**Your Ref:** OWPC14807  
**Our Ref:** BN/20/17/HH 16-05-2017  
**Please ask for:**  
Richard Temple

Demolish existing unit & replace with a replica roof extension  
Clytha Cottage Yapton Road Barnham

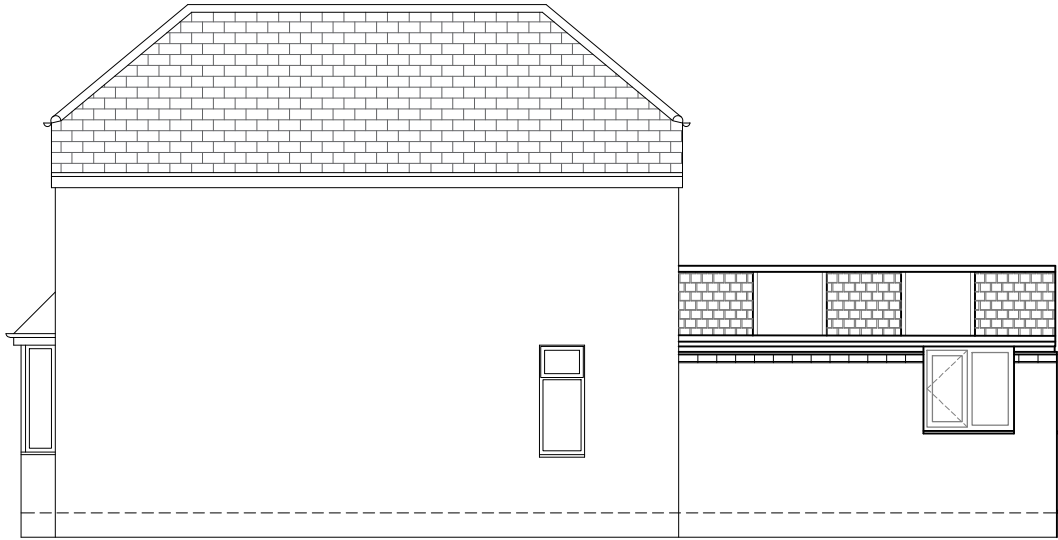
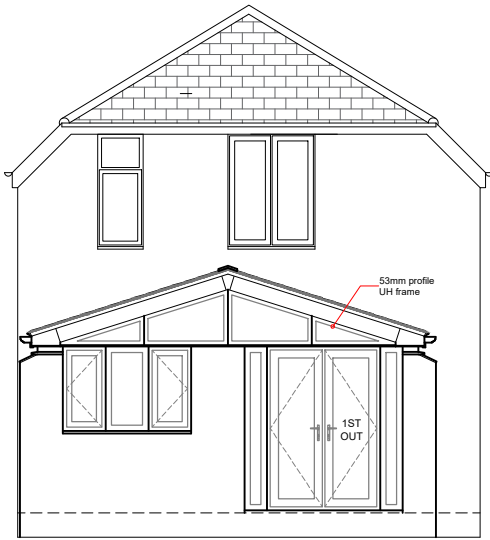
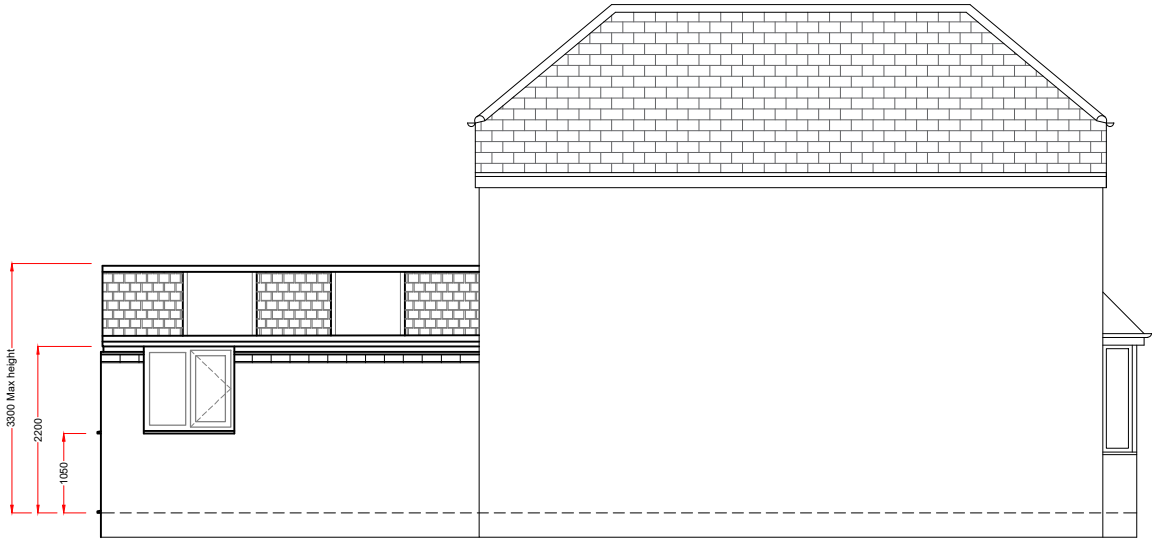
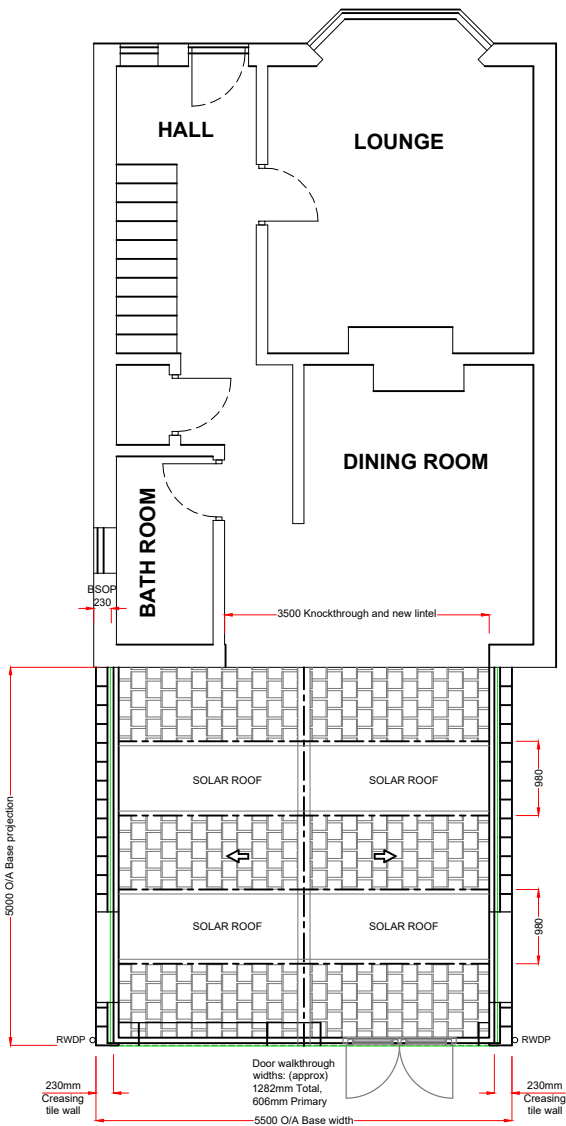
*The proposed extension to replace with a replica roof extension is not in keeping with the rest of the house. The materials are very different to the tiles already existing on the main house and will be a visual eyesore.*
